From: Adam Birkett
Sent: 04 August 2017 12:06
To: Sharon Craig
Subject: FW: Application 3/2017/0317

From: Bloomer, David [<mailto:David.Bloomer@lancashire.gov.uk>]
Sent: 31 July 2017 11:44
To: Adam Birkett
Subject: RE: Application 3/2017/0317

Dave Bloomer
Highways Development Control
Lancashire County Council

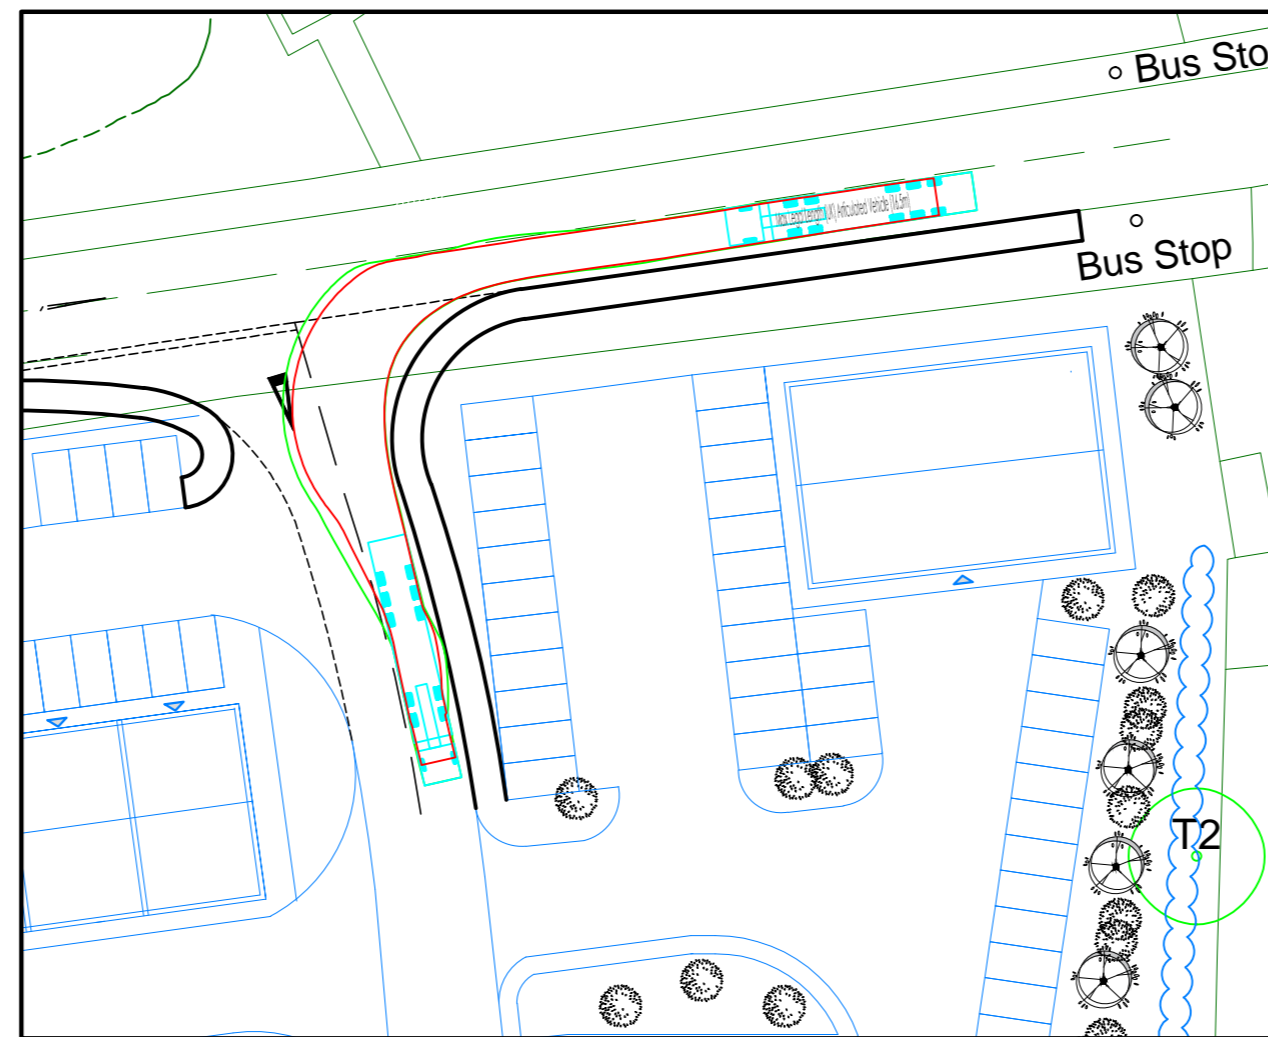
I would need to see a revised access layout taking the access away from the easement. I would regard this as fundamental because on the current layout there is likely to be a traffic management issue for vehicles entering / leaving the site if maintenance to the pipe was being carried out. If the site was put forward for adoption, the current layout re the pipe easement would not be acceptable for the S38.

3 a kerbed buildout outside the Corporation Arms to deflect and reduce the speed of left turning traffic
